**Harvests
Norton Lane
Norton
Chichester
West Sussex
PO20 3NH**

Planning Application AL/107/25/PL

Reference	AL/107/25/PL
Status	Undecided
Proposal	Demolition of existing tennis court and erection of a commercial building (within Use Class E(g)), parking, landscaping and other associated works. This application is a departure from the Development Plan, may affect the character and appearance of the Norton Lane, Norton Conservation Area and is in CIL Zone 3 (Zero Rated) as other development.
Location	Land at West Barn Old Dairy Lane Norton PO20 3AF
Parish	Aldingbourne
Case Officer	Mr S Davis
Received	20-10-25
Validated	27-10-25
Decision By	26-01-26
Comment By	22-12-25
Applicant	Biodot Limited West Barn Old Dairy Lane Norton PO20 3AF
Agent	Gillings Planning Ltd 2 Wessex Business Park Colden Common Winchester SO21 1WP

Block Plan

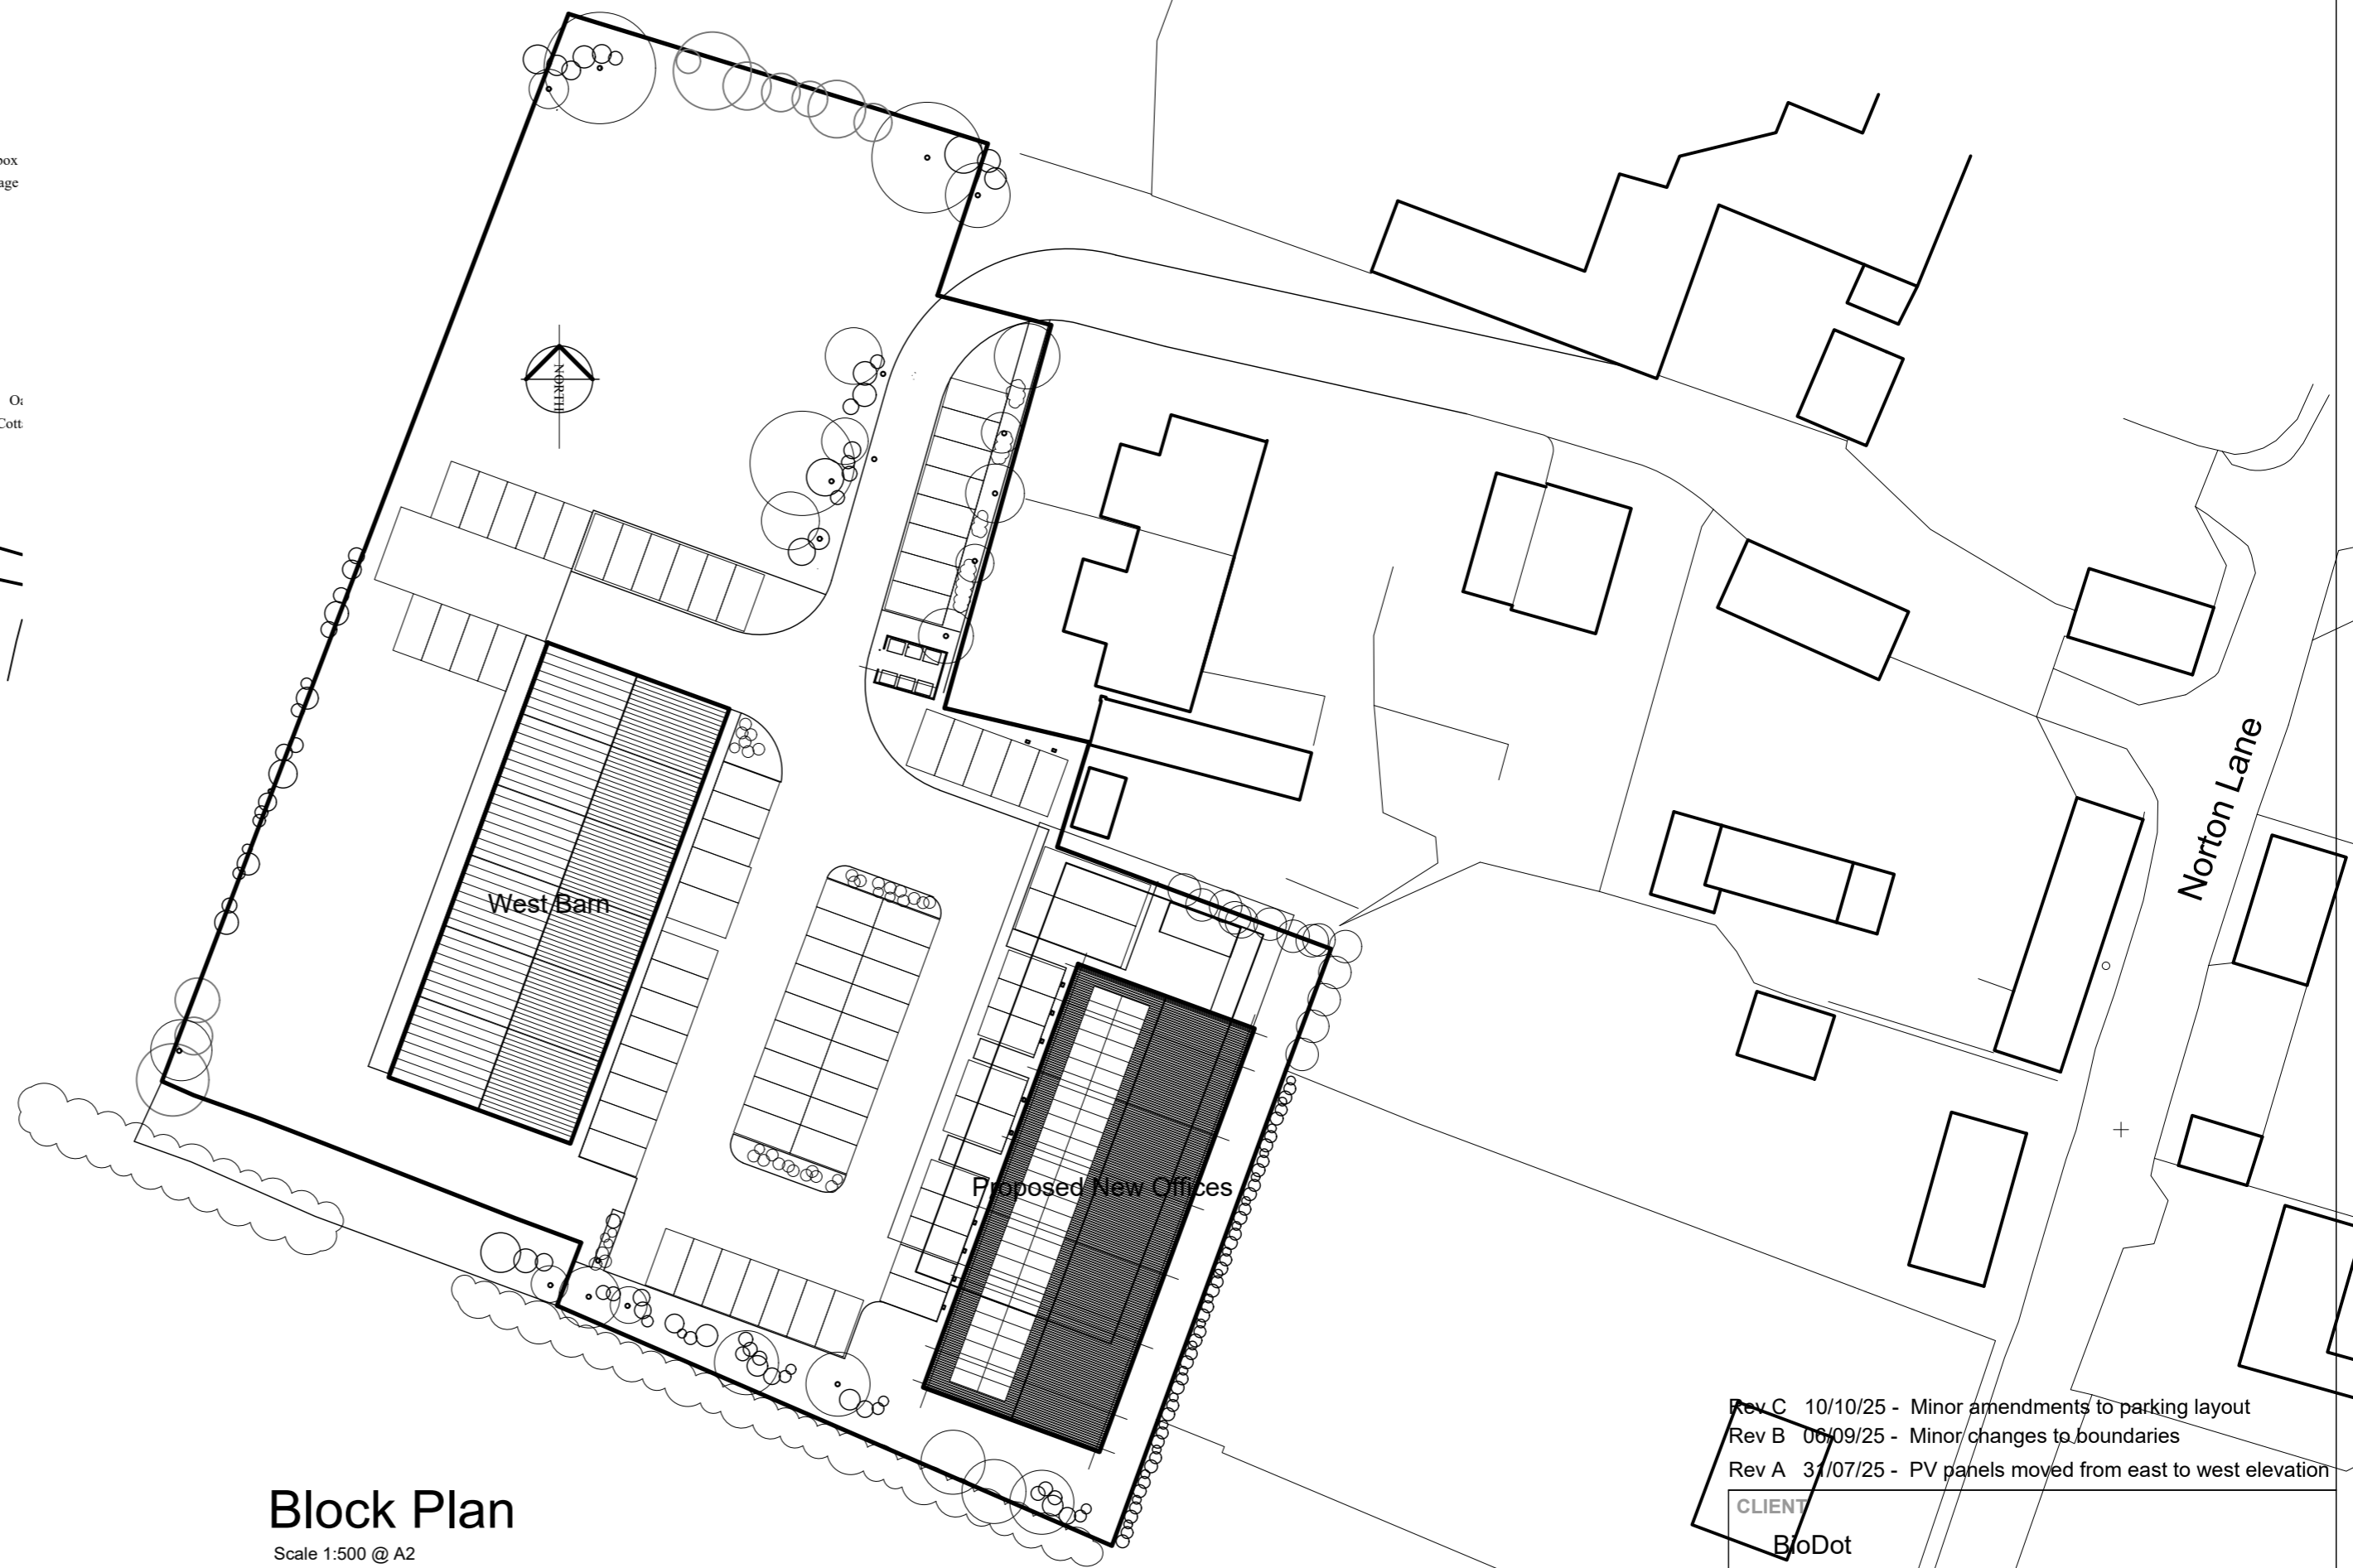
- The access to the site does not afford suitable (25m) visibility in either direction
- This is a new build site and although the applicant has provided a swept path analysis on the site no such assessment has been provided at the entrance of the site (Old Dairy Lane / Norton Lane junction). It is important to note that this is not an extension to an existing building it is a proposed new commercial building and the access requires assessment on that basis
- Please see my objection letter of 20th November (posted on the Arun DC planning portal) where I provide photographic evidence that HGV vehicles currently cannot access the site. They park in Norton Lane and transfer the goods along Old Dairy Lane by forklift truck. Whilst this operation is in progress Norton Lane is partially blocked causing safety concerns for road

I strongly urge WSCC Highways to undertake a swept path analysis of the entrance. In fact, I cannot understand why this has not been undertaken to date. This is now particularly relevant as the true constraints of the access are now clear as adjacent landowners have now fenced their property and the true dimensions of the access are now visible. (See photo under the heading 'Clarity on Site Access')

- The applicant advises 5 additional employees but there are 36 additional car parking spaces. As the applicant does not own the site who can guarantee that the building will not be put to an alternative use utilising the 36 spaces?

The entrance between two brick gate pillars to Dairy Lane is only 3.44m in width. There are 2 No parking spaces for the residential property ‘Long Barn’ (Formerly known as ‘The Hovel’) adjacent to the entrance on the left-hand side whilst the property ‘East Barn’ (first on the left in Dairy Lane) also has 1 No private parking space. These parking spaces restrict vehicle movements into Dairy Lane (see Plate 1). This is certainly insufficient to permit two vehicles to pass simultaneously and creates a current access issue even without the additional traffic movements associated with this proposed development. It is also important to note that the applicant does not own the brick pillars of the gateway neither does the owner of the tennis court.

Further to your comments below, the applicant has corrected their red edge to remove the part they included which is a parking space to East Barn. Residents are keen that we re-consult Highways on this point, but I am not doing so as I don't consider it a material change. The change is shown ringed in blue below:

This email deals with the incorrect boundaries shown in the original application.

Yes, the resident has been asked to move his car but it is parked on land in his ownership and he will not always be available to move his vehicles should he so wish.

Local residents have undertaken informal sight line measurements and the access would appear to be non-compliant with the relevant standards in both directions.

In summary, I would strongly urge WSCC to conduct a swept path analysis of the access to Old Dairy Lane owing to the perceived non compliances and safety hazard concerns. It is important to note that this is not an extension to an existing building it is a proposed new building and the access requires assessment on that basis.
